Extended Family Dwelling Request For:  
**Randall & Gwyndena Petrick**  
14195 Silverton Rd  
Colorado Springs, CO 80921

**GUEST HOUSE FLOOR PLANS**

**A1**

UPPER FLOOR PLAN

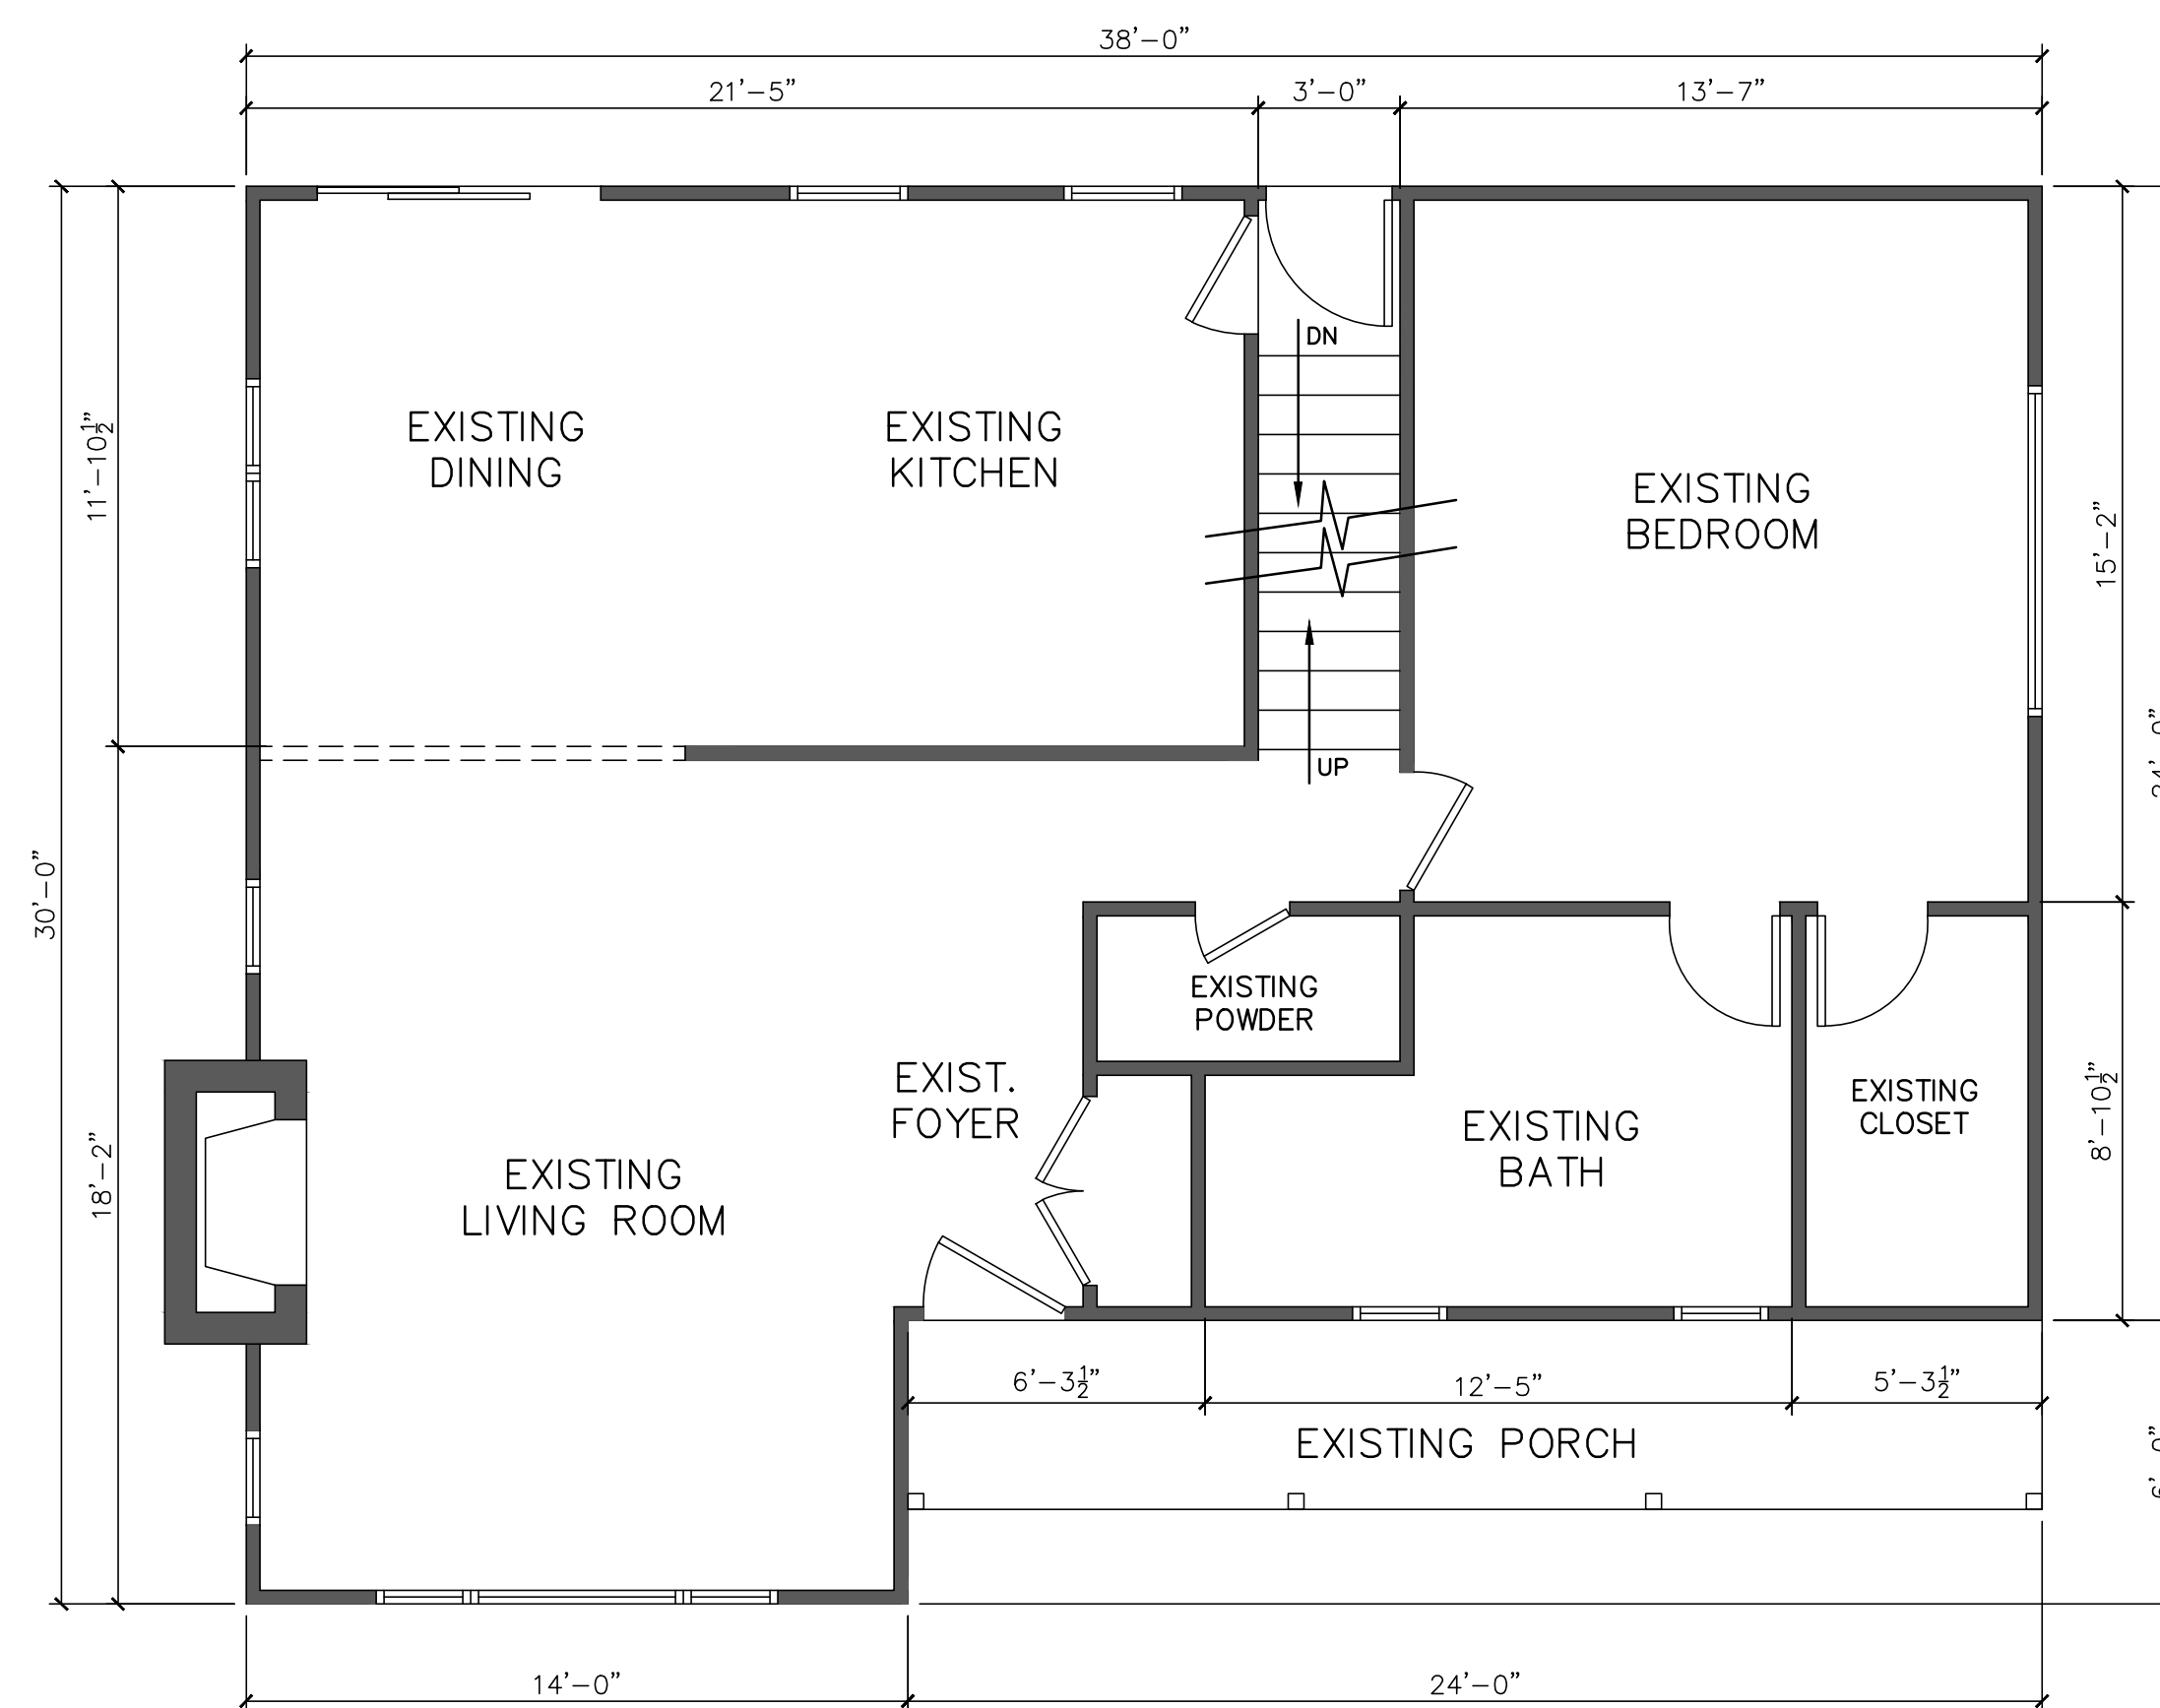
2,521 square feet  
Must request guest house area relief in Special Use letter of intent.
